From: Ben Daines [REDACTED]
Sent: Friday, June 26, 2020 2:26 PM
To: Maria Tomalova <Maria.Tomalova@arun.gov.uk>
Cc: Daniel Vick <Daniel.Vick@arun.gov.uk>; Chris Barker <[REDACTED]>
Subject: RE: Stakers Farm

Please find amended plans addressing the concerns raised in our numerous correspondence. The key amendments are as follows:

Drawing Title
Proposed Plans - Barn 1

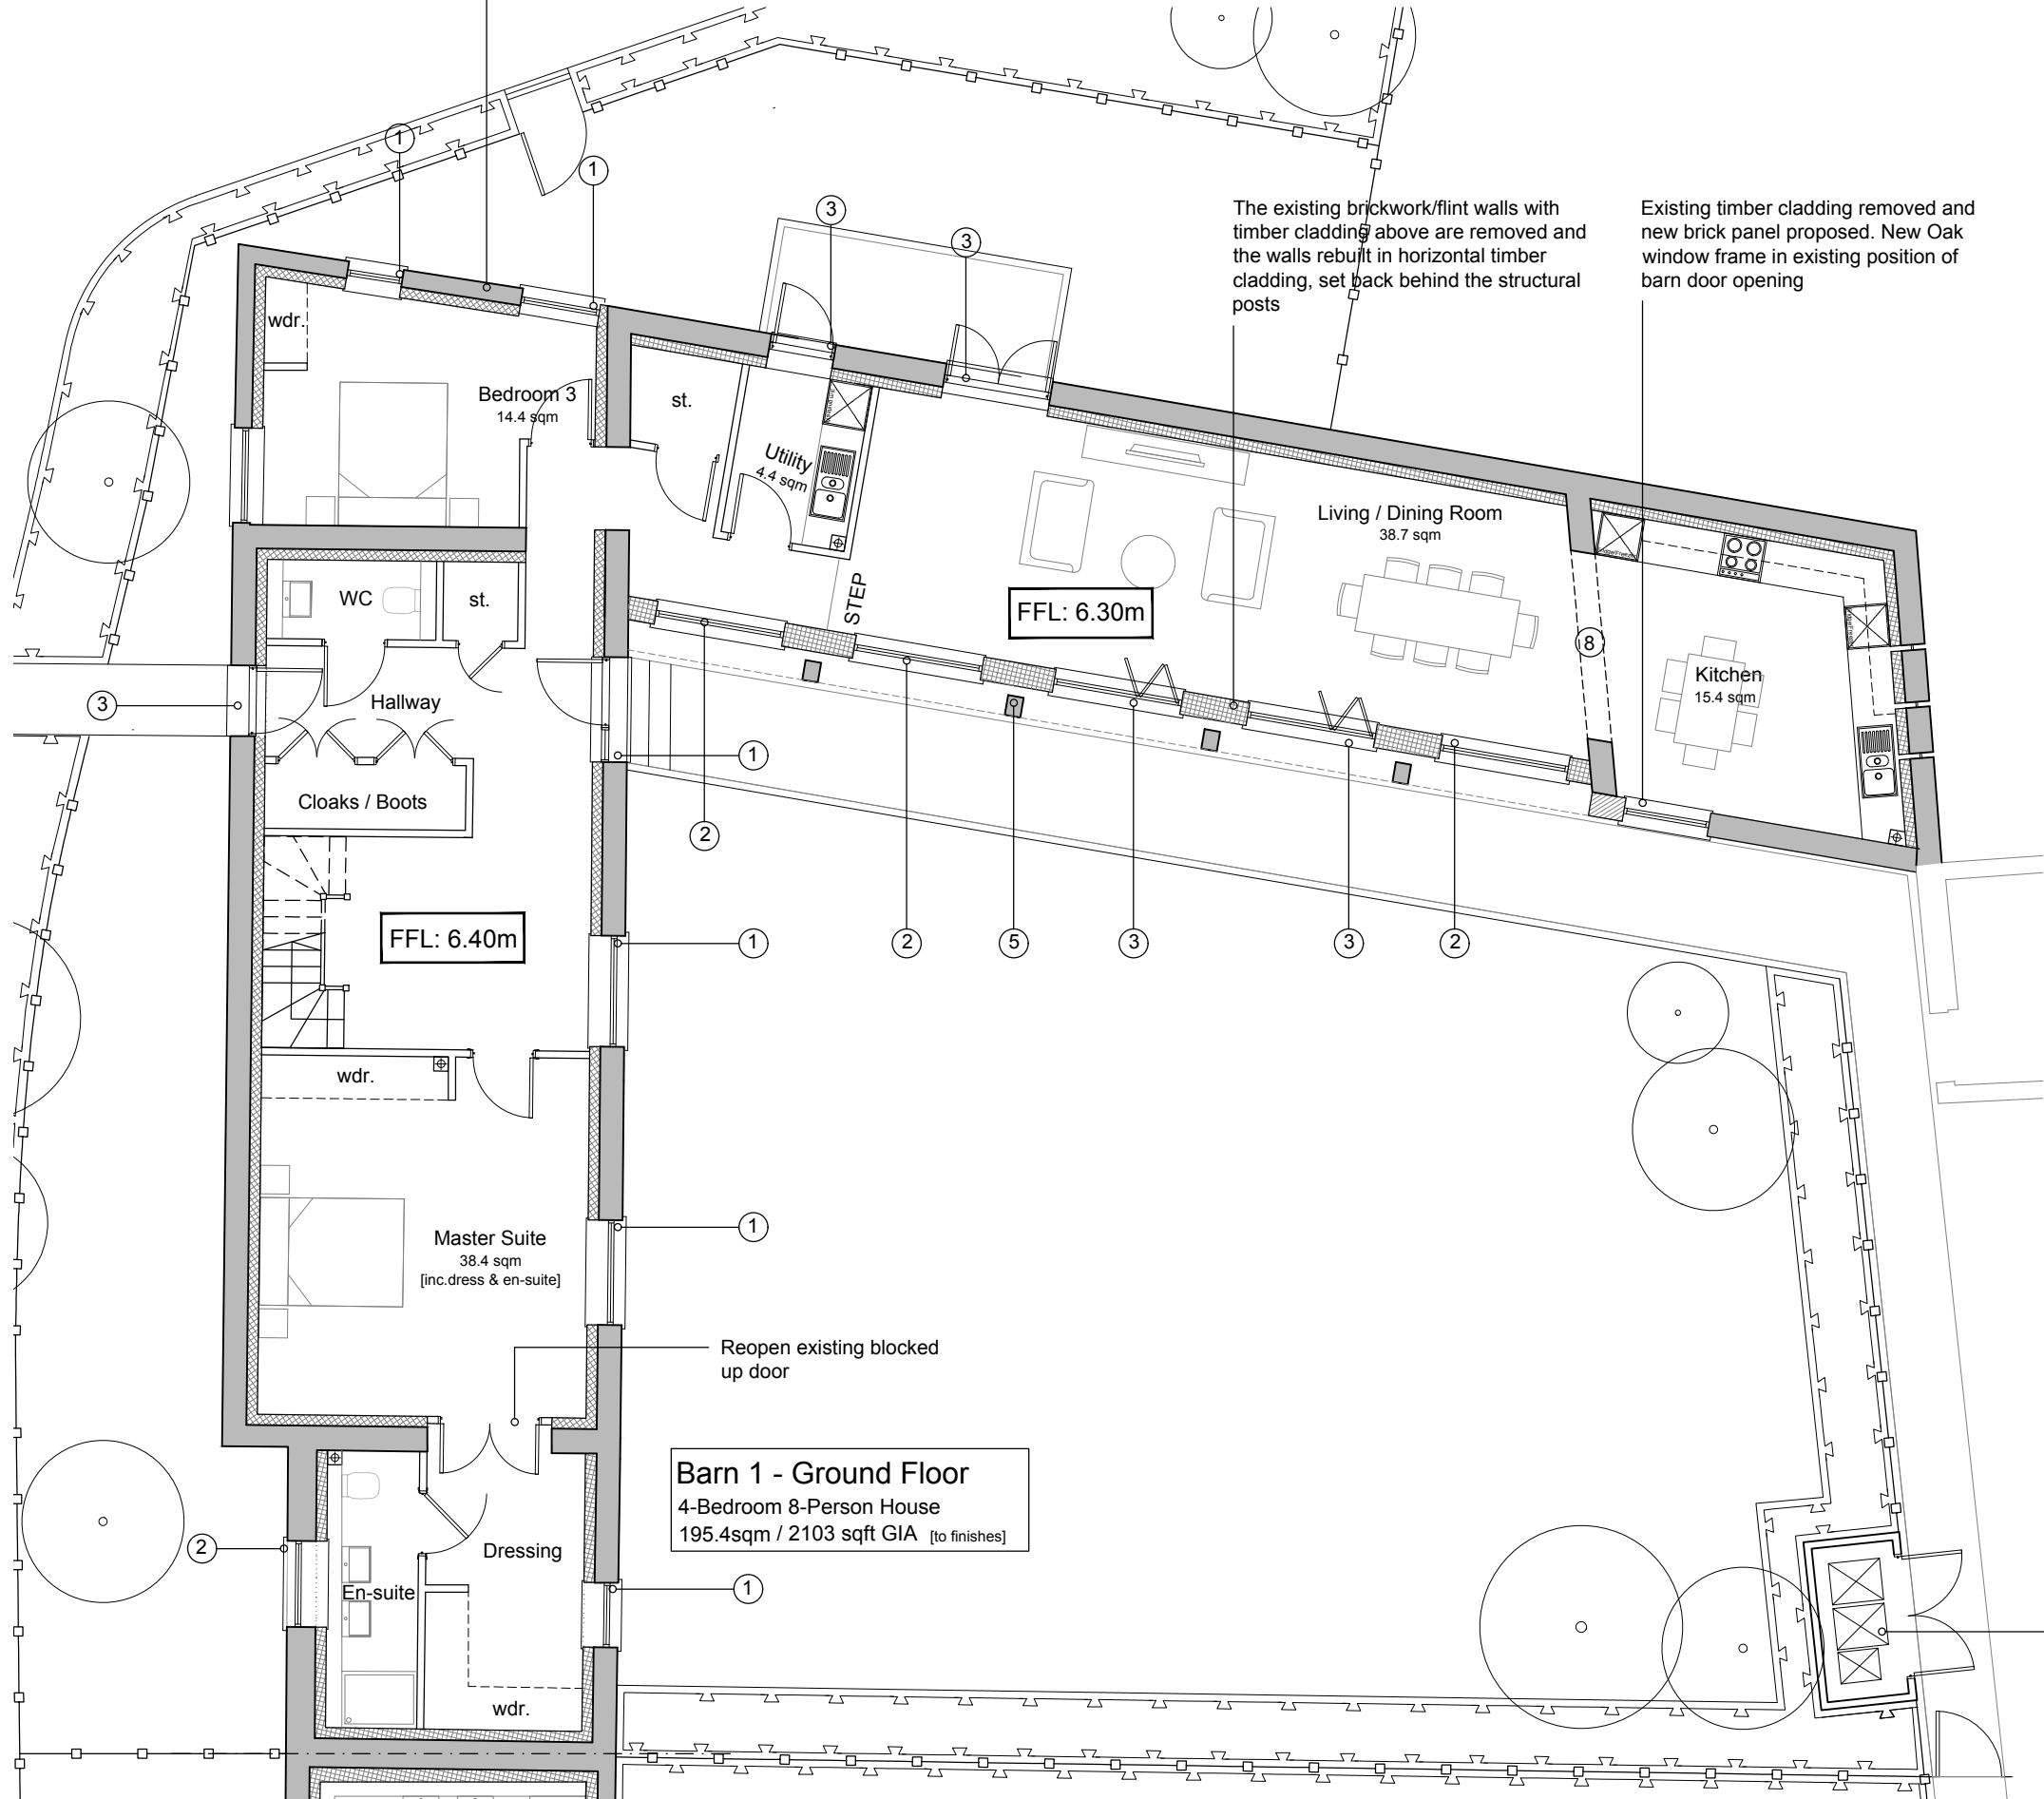
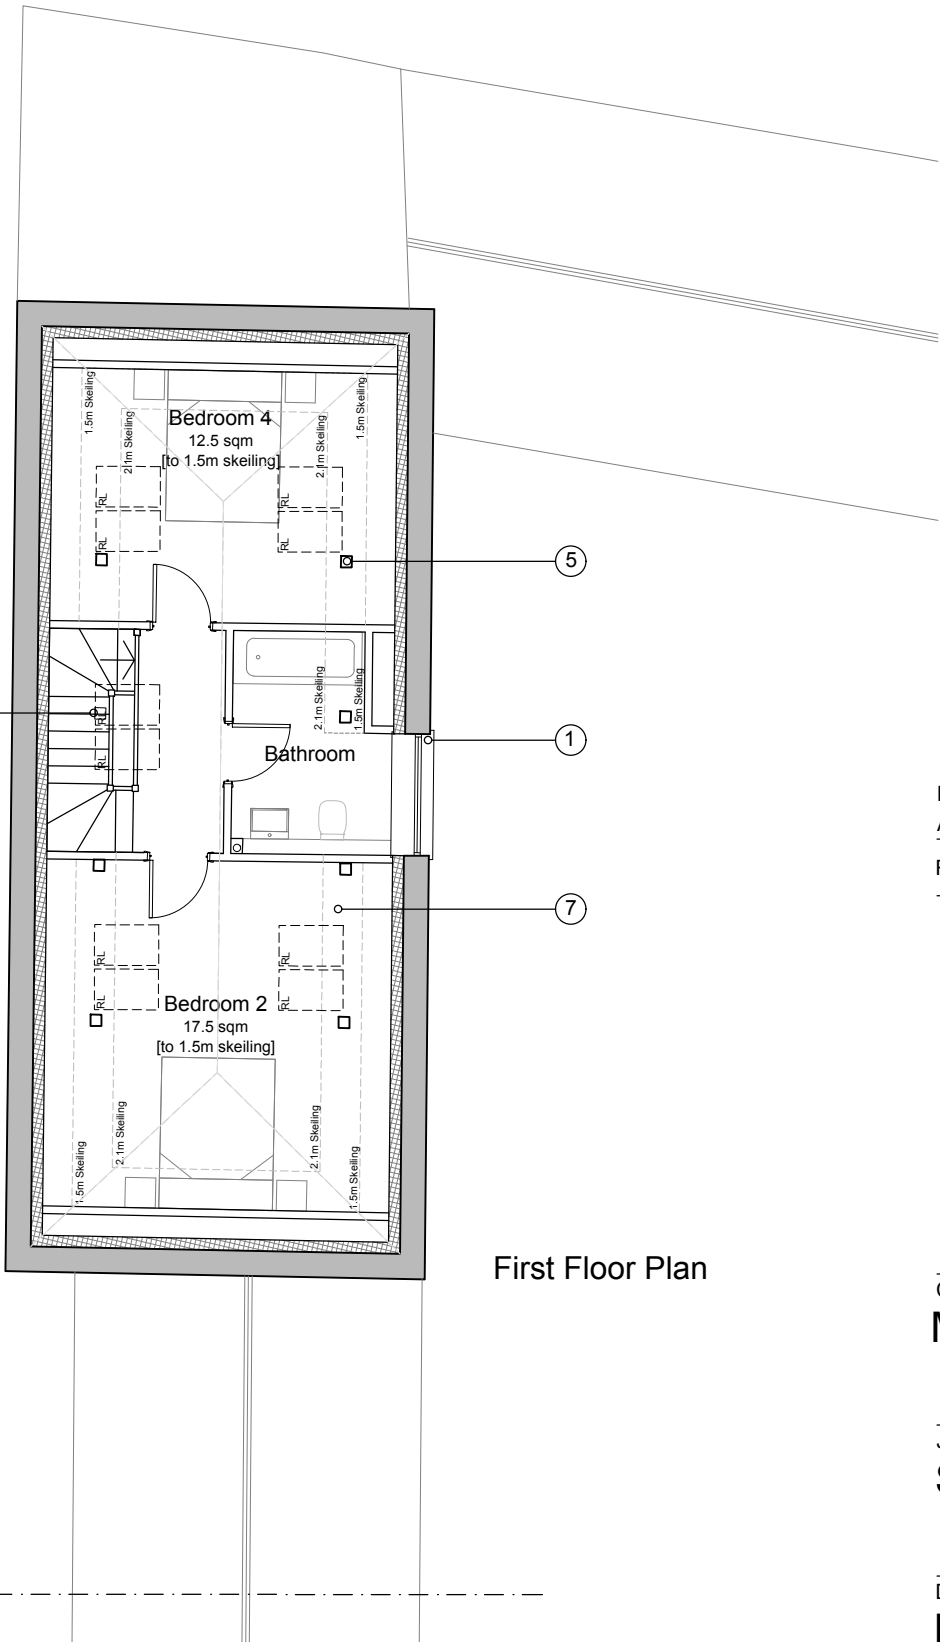
- General note on plans covering the joinery of windows and doors
- Regarding the interior of Barn 1, we have had to be realistic on what features we can retain in order to make the houses fit for habitation. For instance, the flint flooring will need to be taken up and appropriate damp proofing, insulation and floor finishes laid to meet building regulation requirements for habitable dwellings. We can however look to re purpose the flint from this area within the car barns or possibly as a feature within the central courtyard space. Similarly, we will need to dress the exposed brick walls with insulation and plasterboard to suitably insulate the dwelling. Whilst the brick wall may not be a feature within the dwelling, this approach will help to protect the wall and offer further longevity to the barns. Where possible the existing timber first floor will be retained as a feature with new insulation and floor finishes dressed on top to meet building regulations for the habitable rooms. Presumably further details in this regard can be addressed pursuant to a condition.
